# CITY OF ALBUQUERQUE

November 2, 2017

Site: Eagle Ranch MVD

**Re: Drainage Ordinance (14-5-2-1) Violations for Erosion and Sediment Control and Construction Site Waste(s)**

## Curb Storm Inlet Protection with Wattles

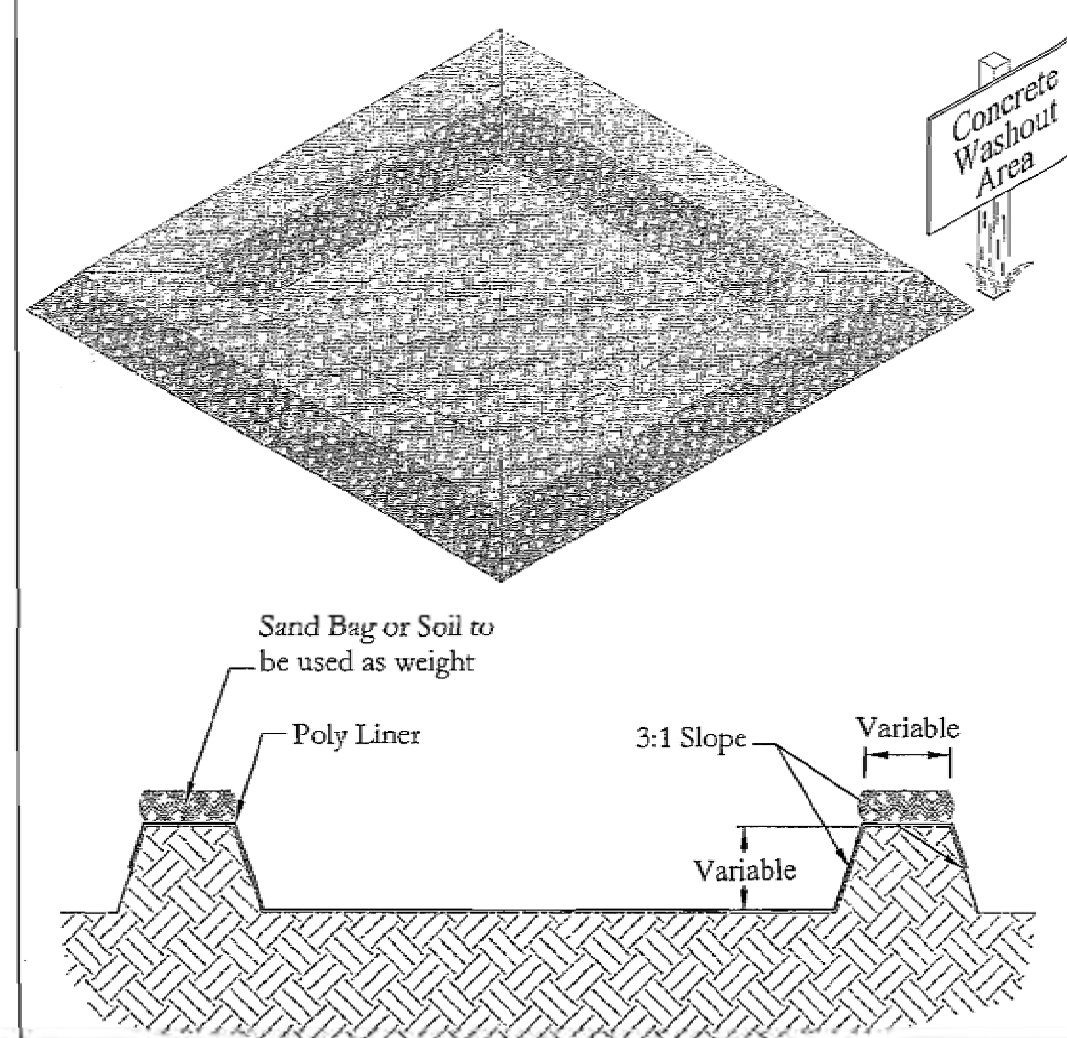
1. No stabilized construction entrance (track-out pad).
2. No BMP for opening into the storm drain system.
3. Concrete wash-out and acceptable wash-out facility was not observed onsite.
4. Disturbed area in the northwest corner without a sediment BMP.
5. No sediment BMP at asphalt interface.

1. Install a stabilized construction entrance (track-out pad) per the approved Erosion and Sediment Control plan.
2. Provide a sediment BMP or cover the opening into the storm drain system.
3. Remove all instances of concrete wash-out and bring-in or install an acceptable wash-out facility was not observed onsite.
4. Provide a sediment BMP or stabilize the disturbed area in the northwest corner of the site.
5. Provide a sediment BMP at the asphalt interface.
